# Rezoning Transportation Analysis

Petition Number: #2022-090

**From:** Jake Carpenter, PE

Date	Description
11-28-22	First Review (TM)

RZ1.00

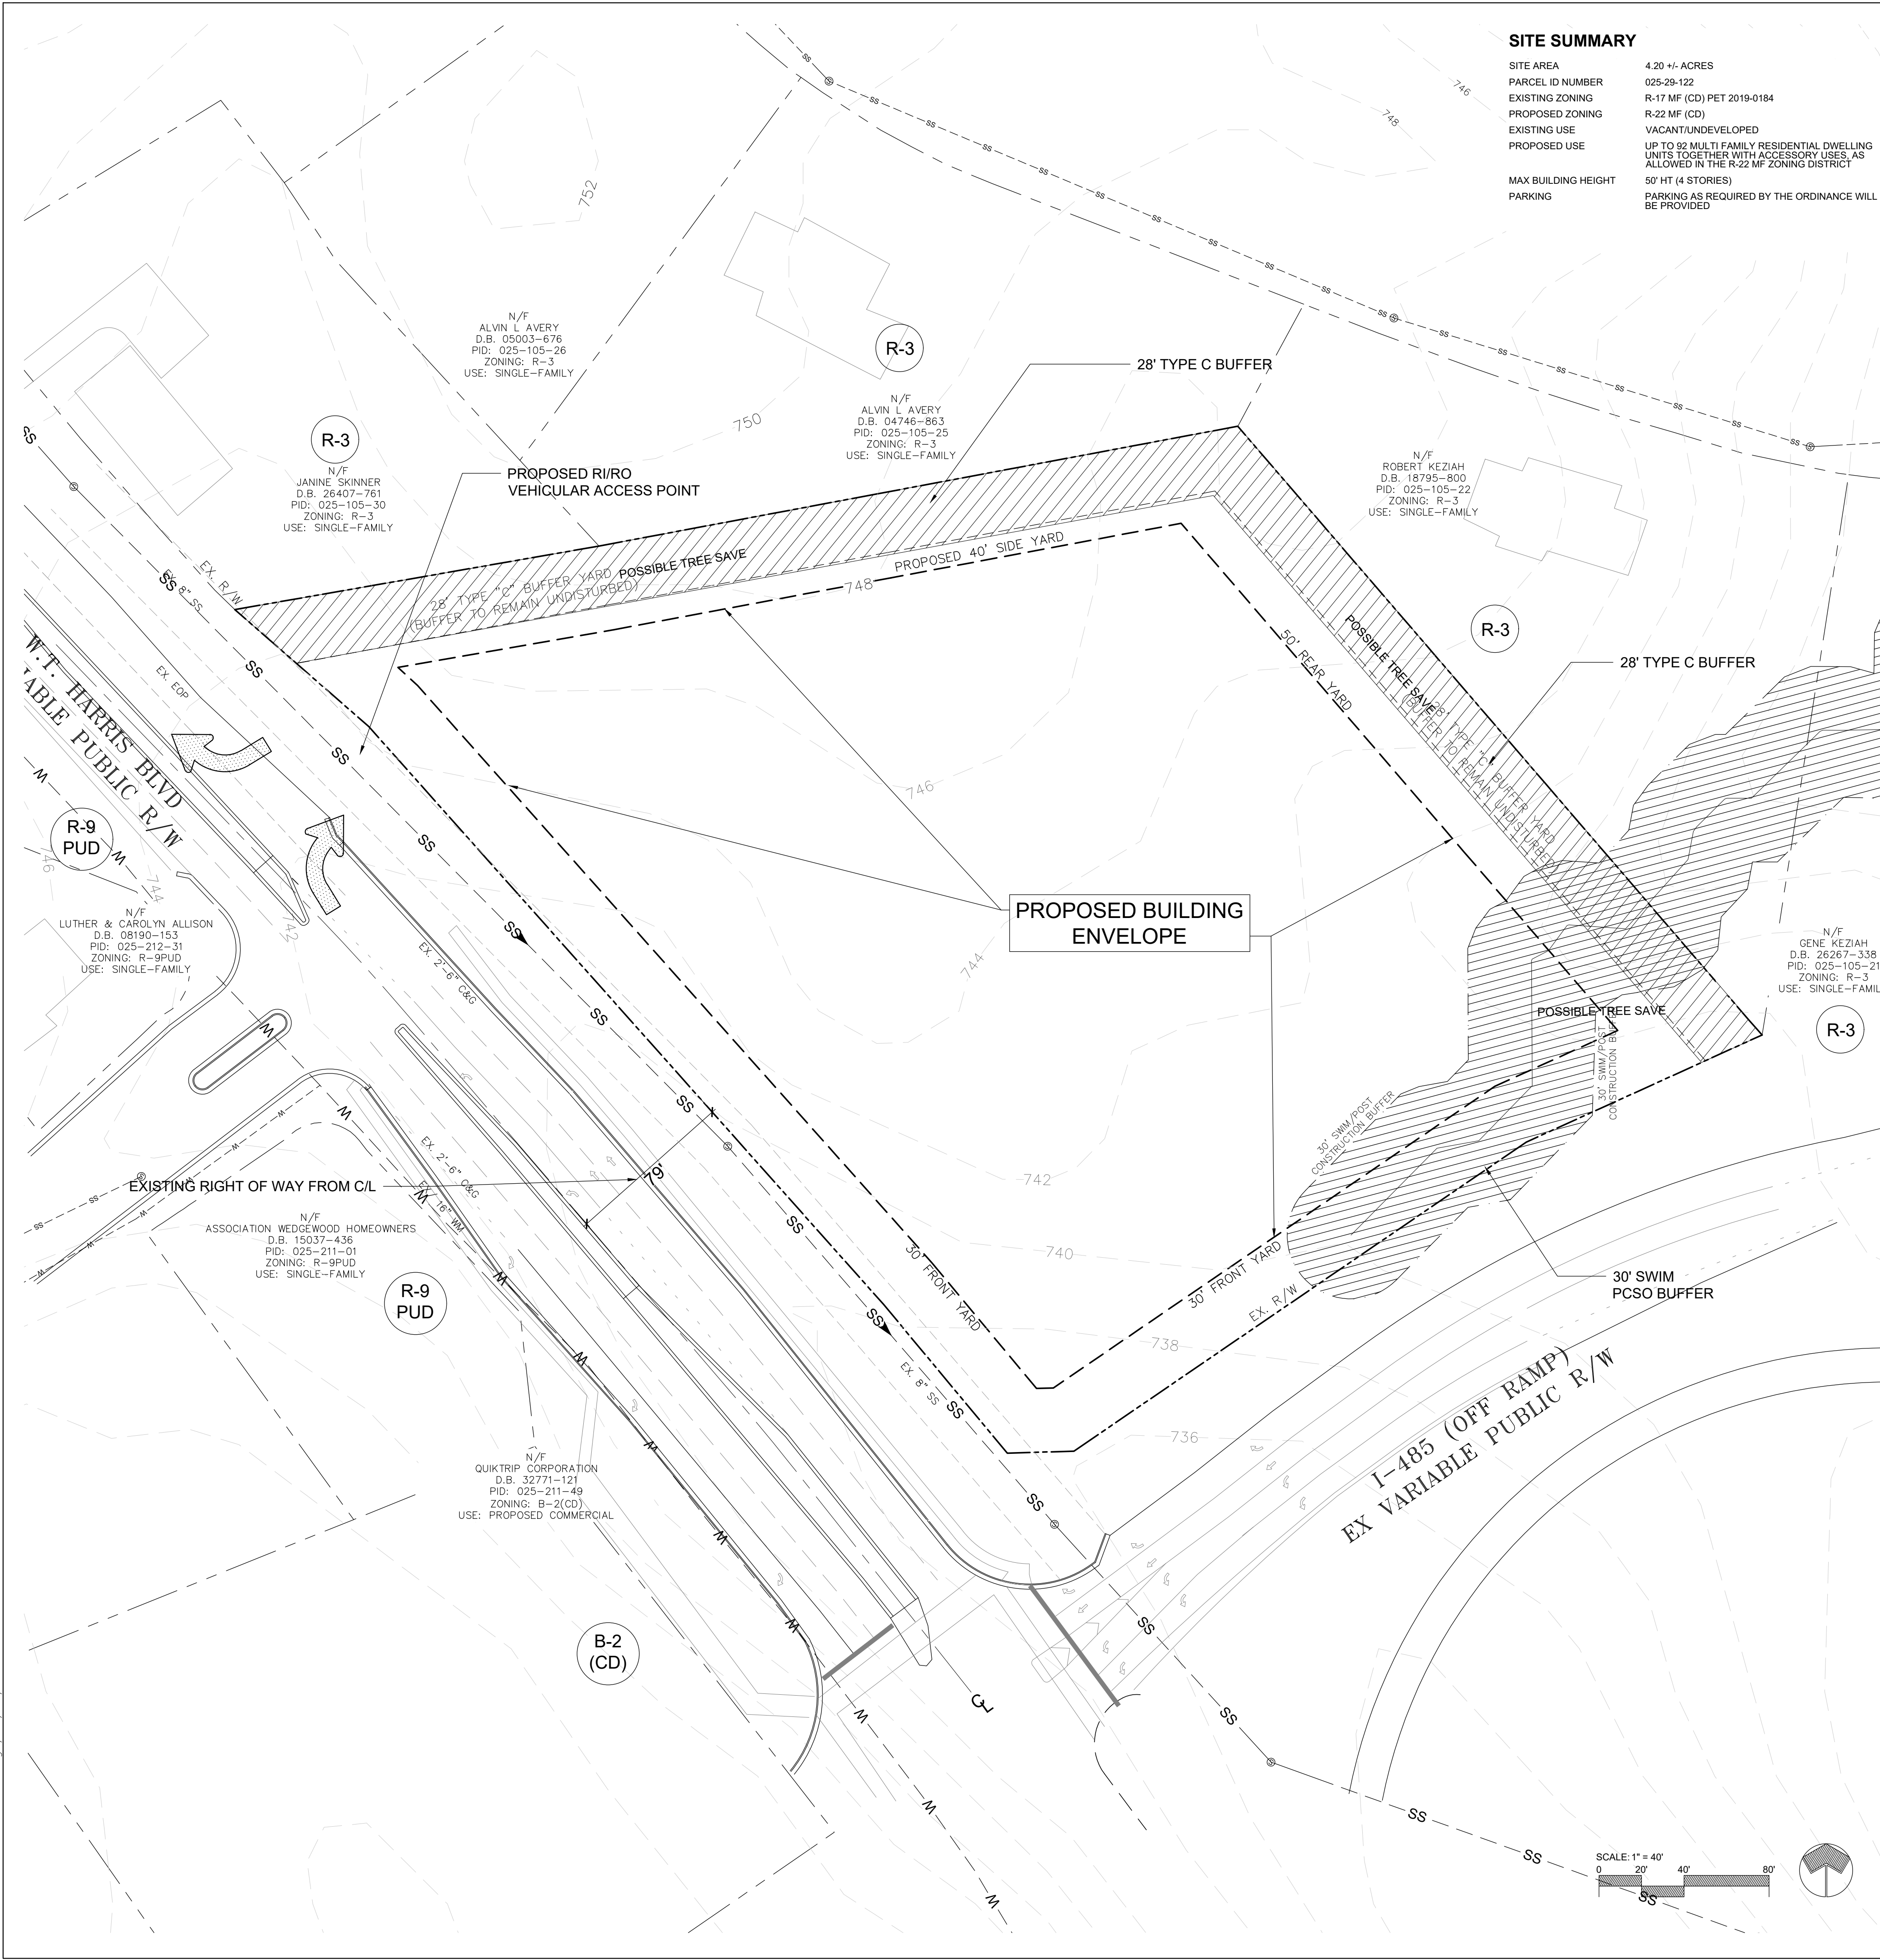
1. **Curbline:** The proposed zoning district has a setback measured from back of the existing or proposed future curbline.
  - a. **WT Harris Boulevard:** The future location of curb and gutter is in its current location. Proposed curb and gutter along site frontage must match existing back of curb.

Label and dimension the curb and gutter from the centerline for each road on the site plan.

3. Revise site plan by labeling and dimension the right-of-way from the road centerline.
4. Site plan and conditional note(s) revisions are needed to commit to construct curb and gutter from existing curb and gutter to the Northern property line of the site. Curb and gutter shall be labeled and dimensioned from the centerline of WT Harris Boulevard on the site plan.

5. Revise site plan by showing proposed 8-foot planting strip, and 12-foot sidewalk on WT Harris Boulevard as committed to in conditional notes. This meets chapter 19 requirements. The site plan shall label and dimension both items from the back of curb and gutter and road centerline.

6. Revise site plan and conditional note(s) to provide a right-turn lane at the site entrance with 100-feet of storage. Site plan shall dimension the storage length and the length of the taper. Add a conditional note noting the right-turn lane improving.

7. Revise site plan and conditional note(s) to provide a 100-foot driveway stem measured from the proposed right-of-way. Site plan shall dimension this from the proposed right-of-way.

Remove existing conditional note 3D.
